**Item No.** **Report of the Interim Director of Planning, Regeneration & Public Realm**

**Address:** 18 THE BROADWALK NORTHWOOD

**Development:** Erection of a single storey extension at rear of existing garage.

**LBH Ref Nos:** 485/APP/2023/128

Drawing No:
2209-PL-120

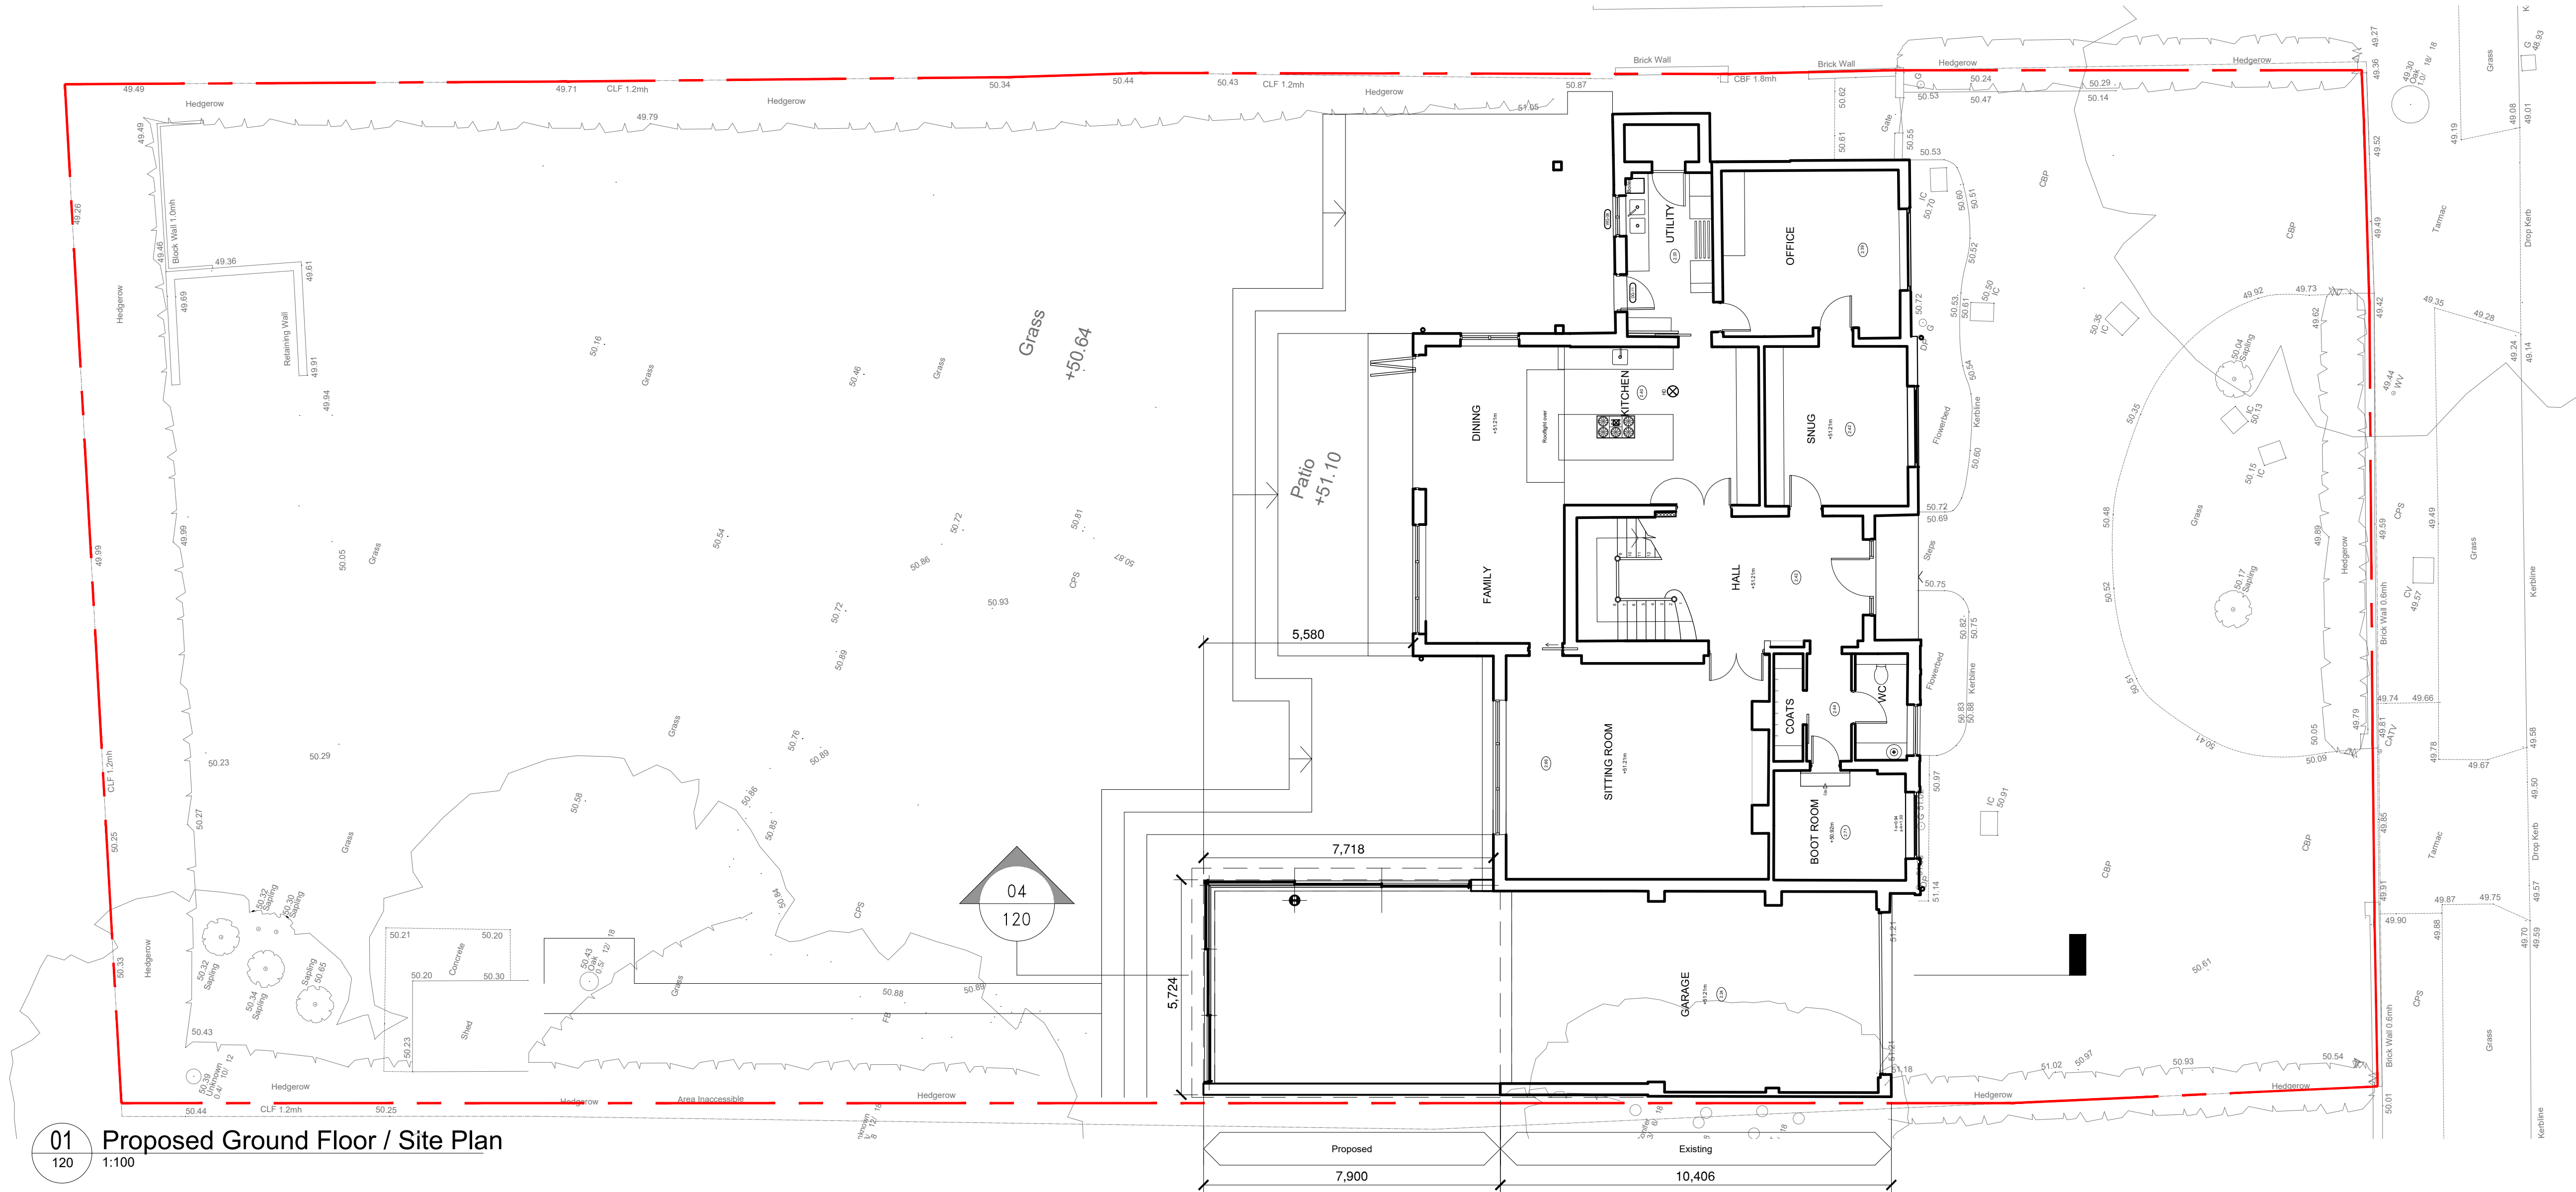
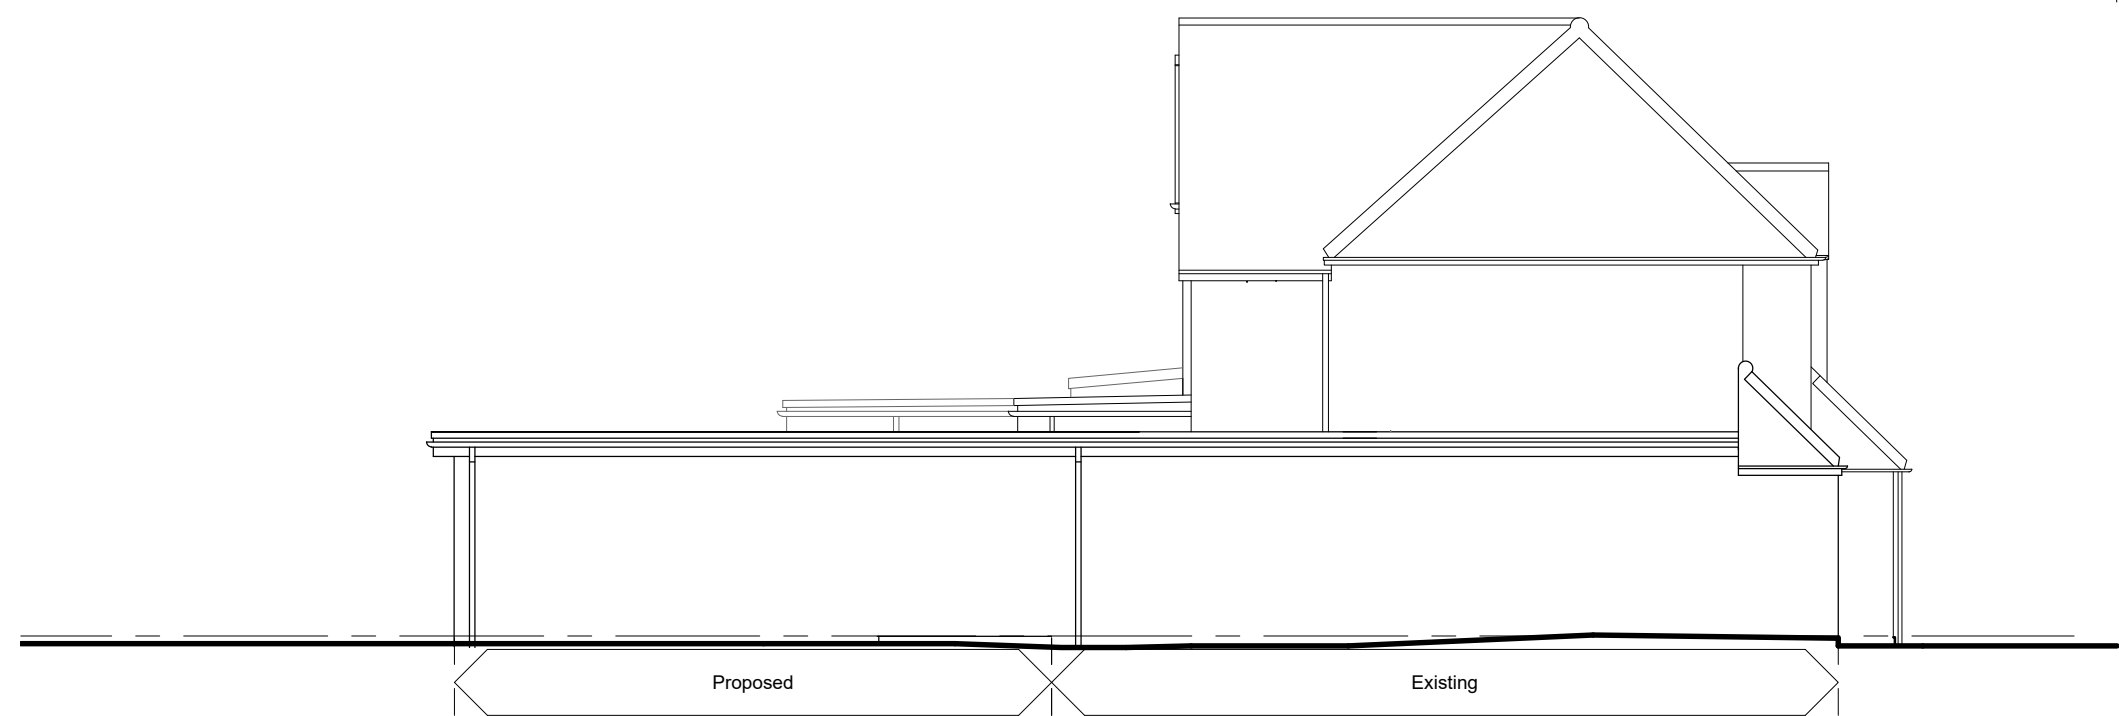
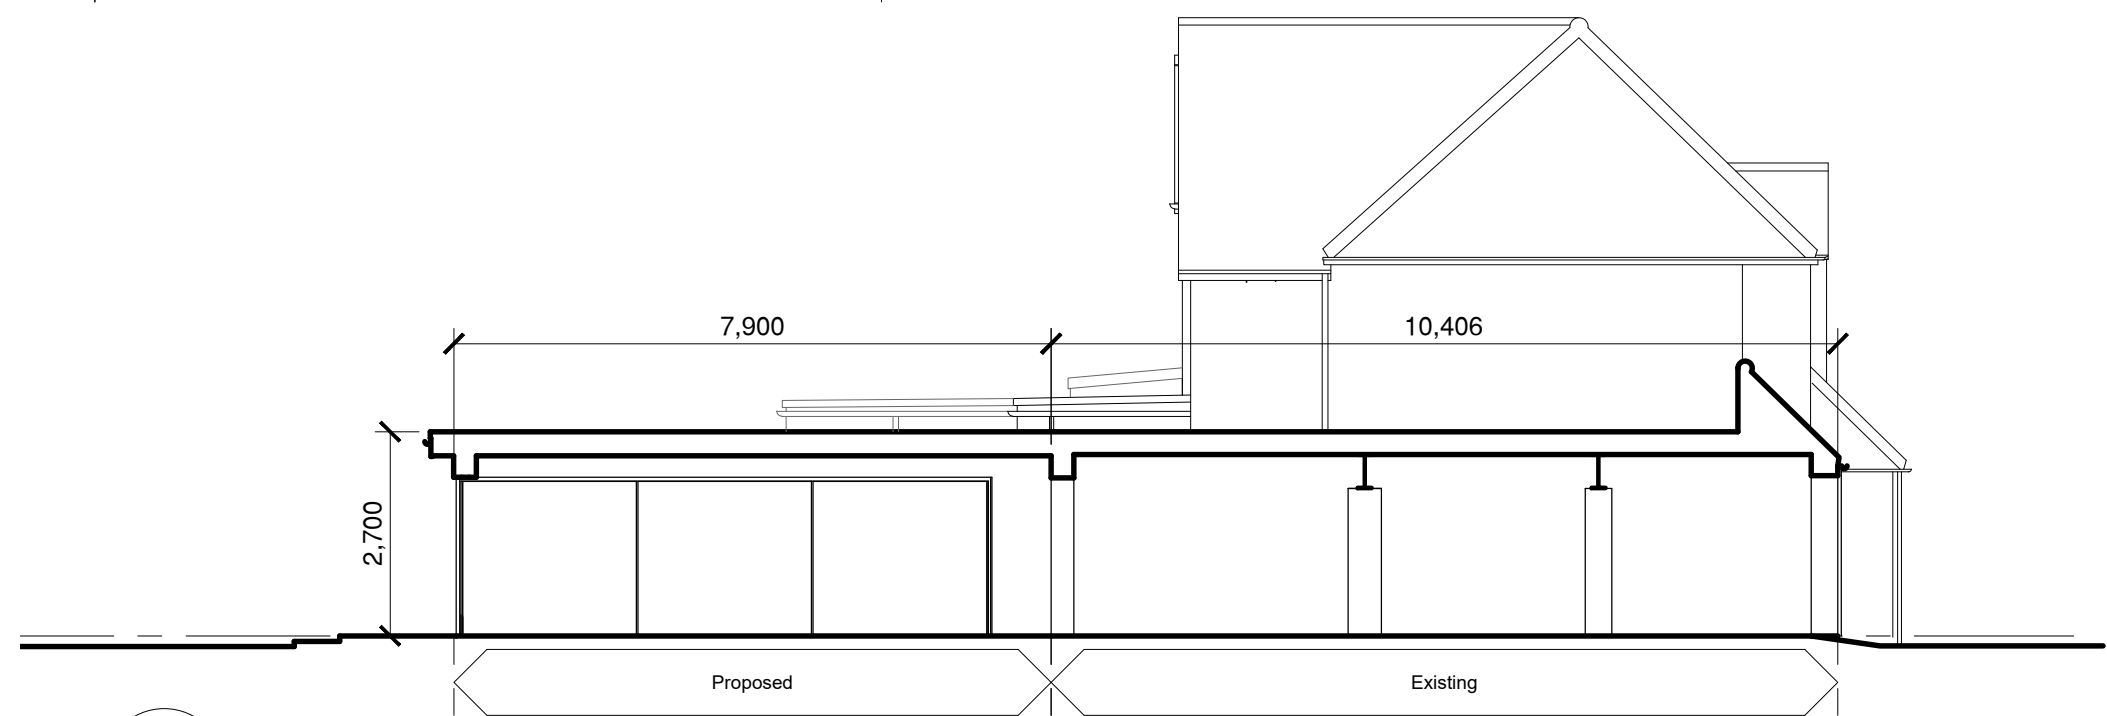
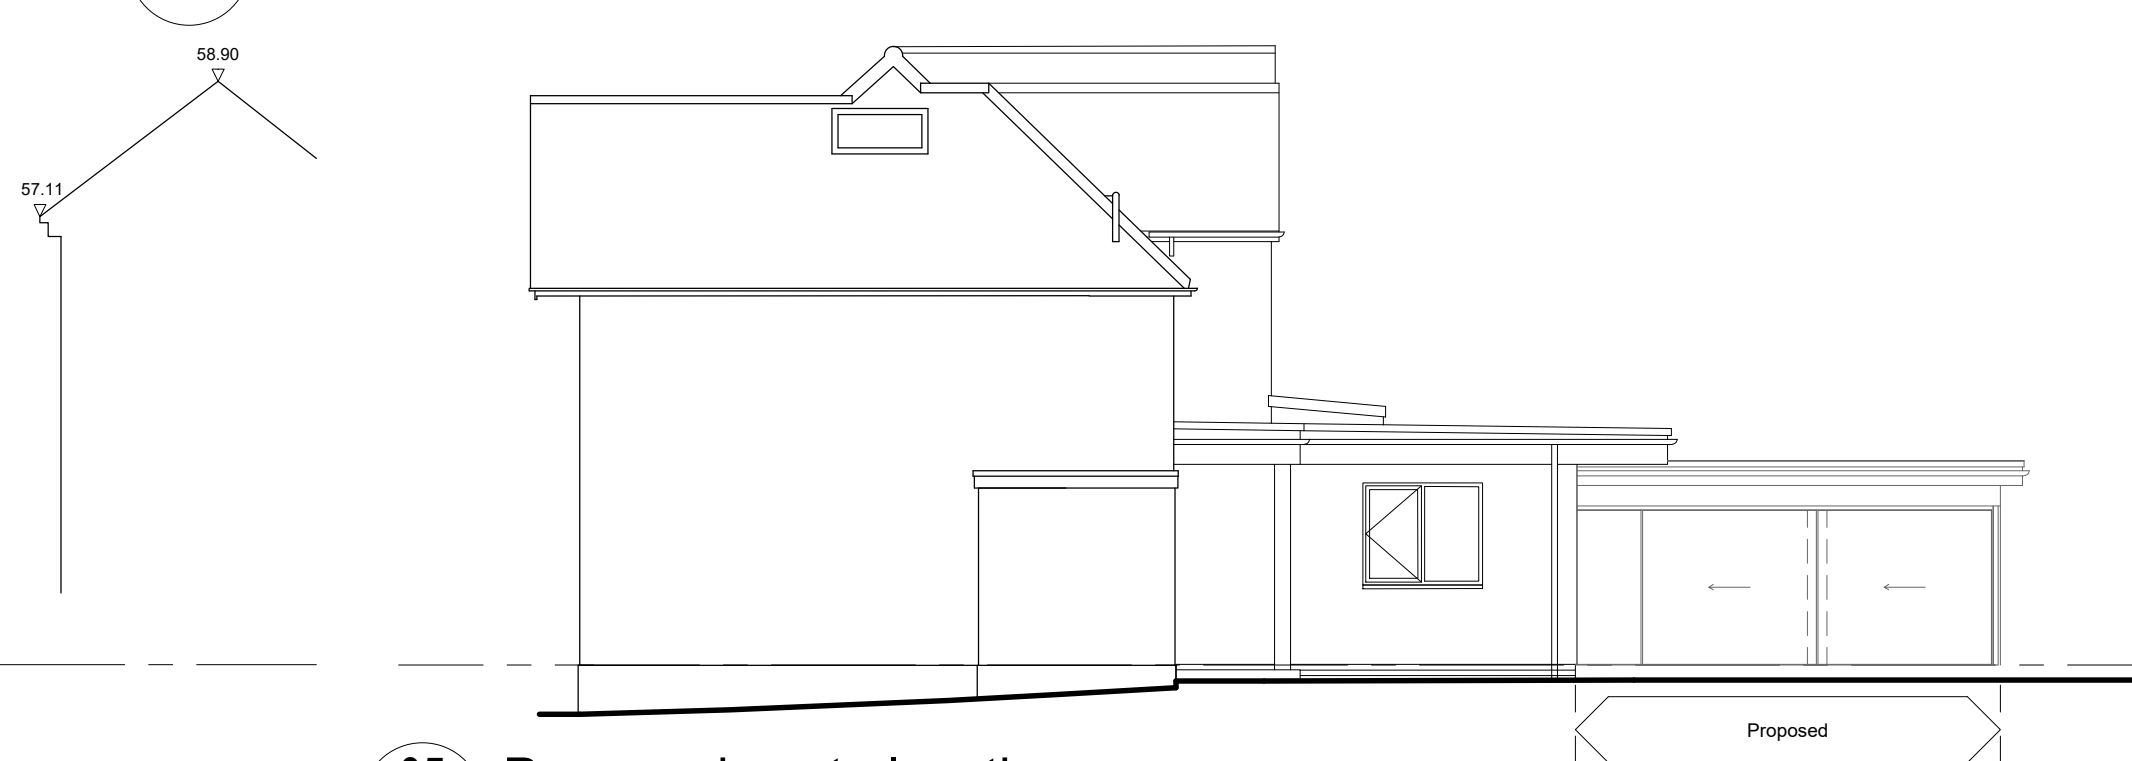
The planning history for the site is listed above. Importantly, an extant permission exists for a rear extension which has not been shown on the drawings.

The proposed extension would measure approx. 7.90m in depth, 5.72m in width and 2.7m in height. The extension would attach to the existing garage extension and be characterised with a flat roof.

The extension does not comply with the prescribed depth in Policy DMHD 1, nor does it contain a parapet wall which is a requirement for developments within an Area of Special Local Character. It is considered that due to the excessive depth and positioning along the boundary, the development would create a bulky and disproportionate addition to the dwellinghouse.

The development would be sited right along the shared boundary line with no.20 The Broadwalk, therefore is contrary to point iv of Policy DMHB 6. Further, given the proximity to the existing soft boundary treatment it has not been sufficiently indicated in the form of an arboricultural survey or tree report that this planting could be retained. Therefore the development is also contrary to point v

The proposed extension would therefore harm the character and appearance of the original property as well as Copse Wood Estate Area of Special Local Character due to its scale, size and siting on top of an already heavily extended rear facade.

Number 20 The Broadwalk is located west of the application site. The proposed extension would be positioned right along the shared boundary with this neighbour. It is noted that the existing garage of the host has been extended in the past and with this proposed extension the total garage and extension would extend approx. 18.3m along the boundary. This would create an overly dominant and unneighbourly addition.

No.20 has planning permission for a 'Part single storey, part two storey side and rear extension' which has not yet been built out. However this would be positioned away from the shared boundary. The proposed extension would be positioned next to no.20's private amenity space and would cause an over dominant and overbearing effect to this space. The soft landscaping along the boundary cannot be guaranteed to remain in perpetuity to successfully mitigate the harmful impact of the extension.
